Our reference: ECM: 9653355  
Contact: Gavin Cherry  
Telephone: (02) 4732 8125

Department of Planning, Industry and Environment  
Attn: Bruce Zhang

**Review of Response to Submissions – SSD-9794683 – Oakdale West Estate Stage 3 Development at 2 Aldington Road Kempas Creek**

Figure 7: Proposed Lots 2C and 2D Vehicular Access

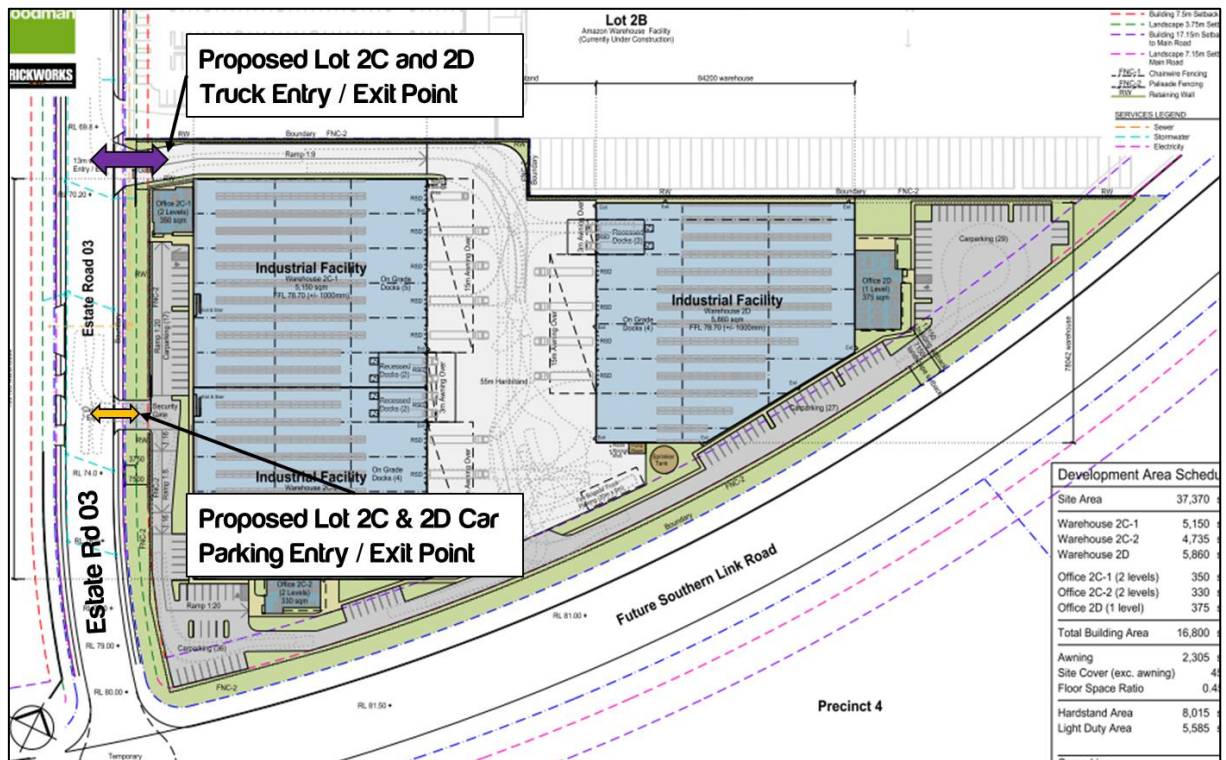
- Vehicular access for the internal car park servicing Building 2D is shared with the heavy vehicle access and manoeuvring areas for Buildings 2C1, 2C2 and 2D which is not supported on safety grounds. This has been

previously raised with the Department and is considered a necessary amendment that must be made.
